# LSC Responses to TIS Redline Comments

Figure 2  
Site Plan

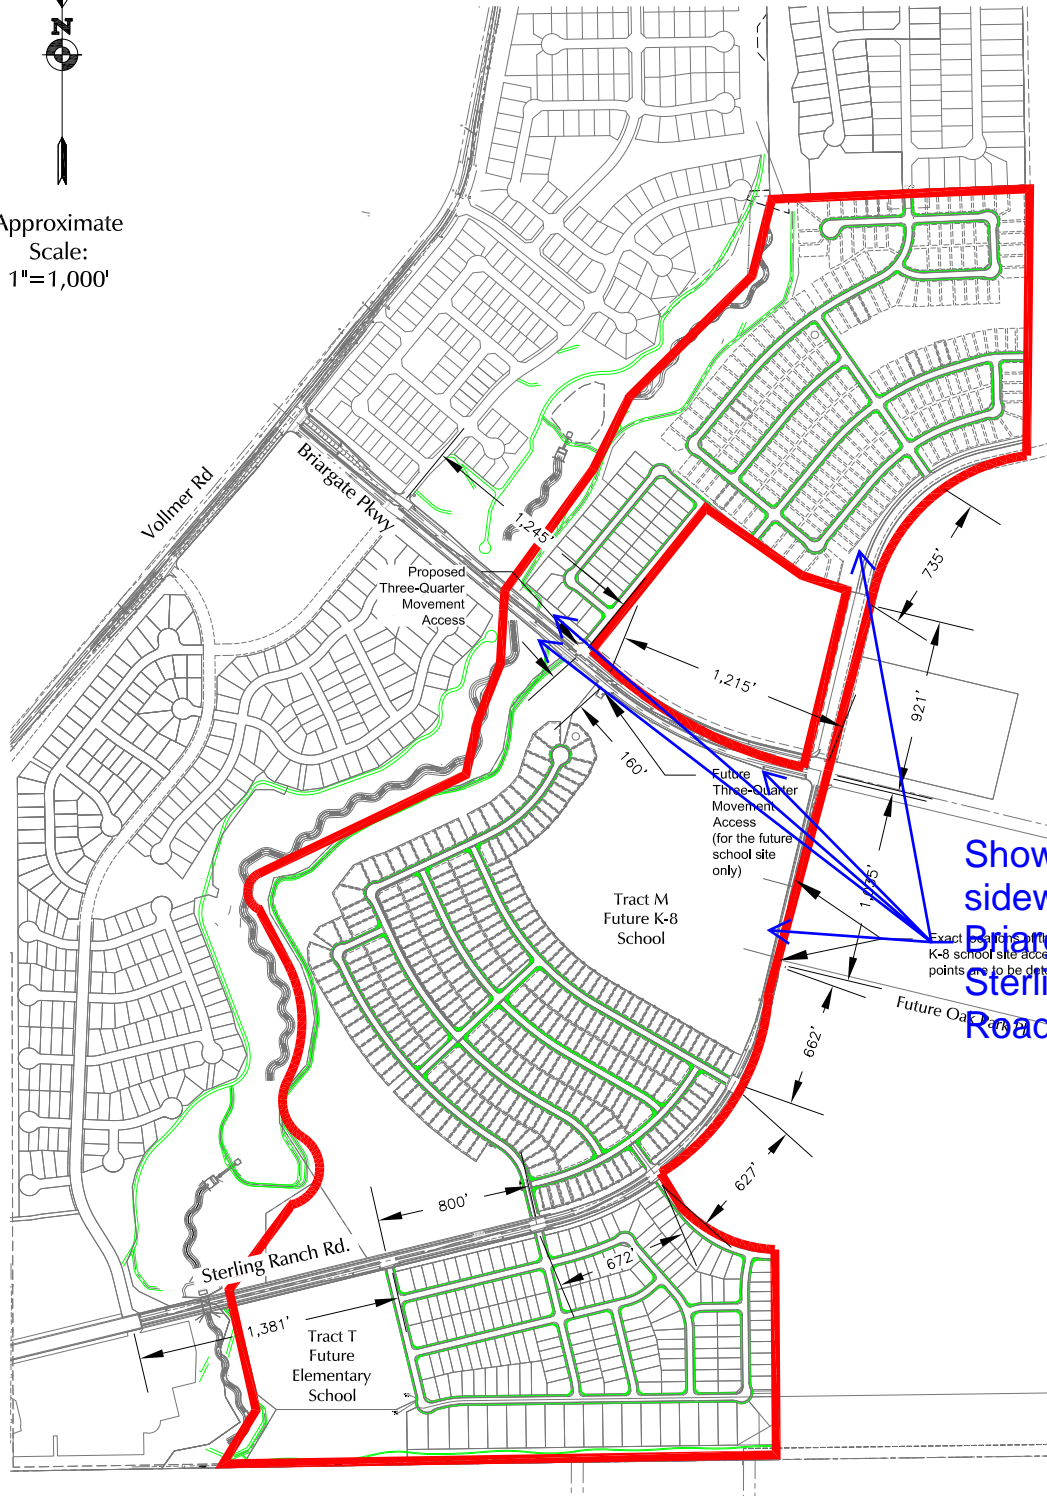
Show and label sidewalks along Briargate and Sterling Ranch Road

Author: kdferrin Subject: Sticky Note Date: 3/15/2023 8:52:01 AM  
LSC Response: The figure has been revised as requested.
